Application for a non-material amendment following a grant of planning permission.

2no. rooflights to existing outbuilding to facilitate conversion to home office;
2no rooflights and re-roof existing garage/store to facilitate conversion to home studio;
stable block/tack room; sewage treatment plant; demolition of existing workshop

Reference number:	<input type="text" value="17/01008"/>
-------------------	---------------------------------------

6. Non-Material Amendment(s) Sought

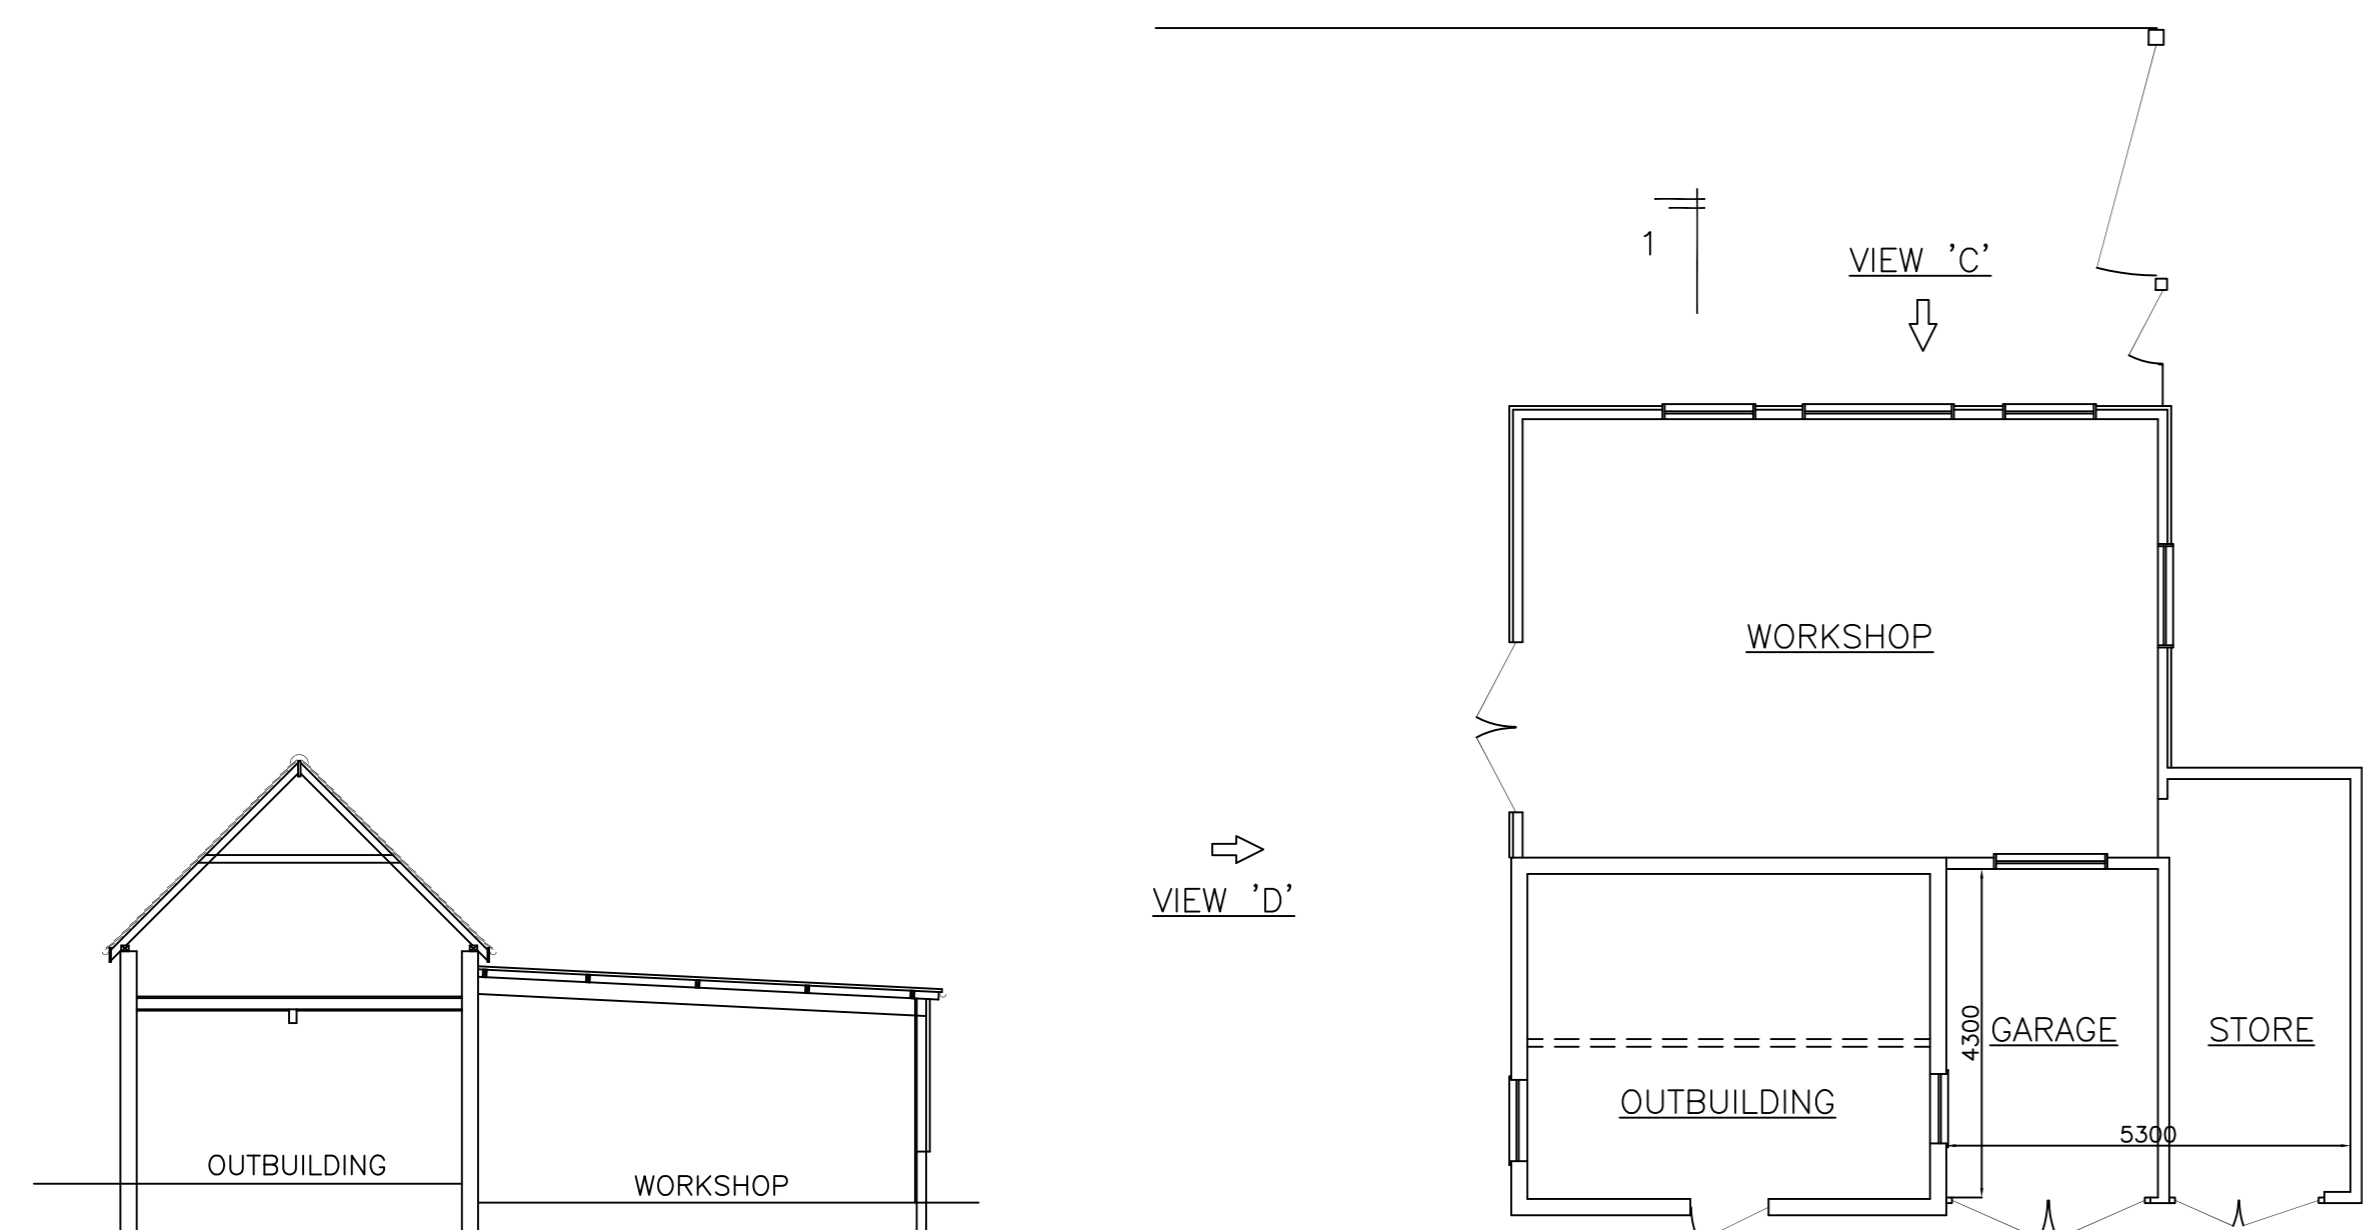
Proposed elevation 'View A' shows oak stable door and frame to home office building and timber folding shutter doors over glazed doors. Proposed elevation 'View B' shows black steel flue removed, higher brick plinth course on home studio and stable building, door removed from stable building, shutter added to stable opening. Proposed elevation 'View C' shows higher brick plinth course and black steel flue removed. Proposed View 'D' shows higher brick plinth course on stable building, shutter added to stable building end opening, unshuttered window to home office, black steel flue removed. Proposed View 'E' shows stable windows removed from stable building and oak posts added. Proposed View 'F' shows higher brick plinth course on stable building and oak posts added.

Drawing 001 Rev F
Drawing 003 Rev B

To accurately reflect the proposed "as built" and the look of the buildings upon completion of the works and to address the issues raised by the enforcement notice Ref QU/21/001.
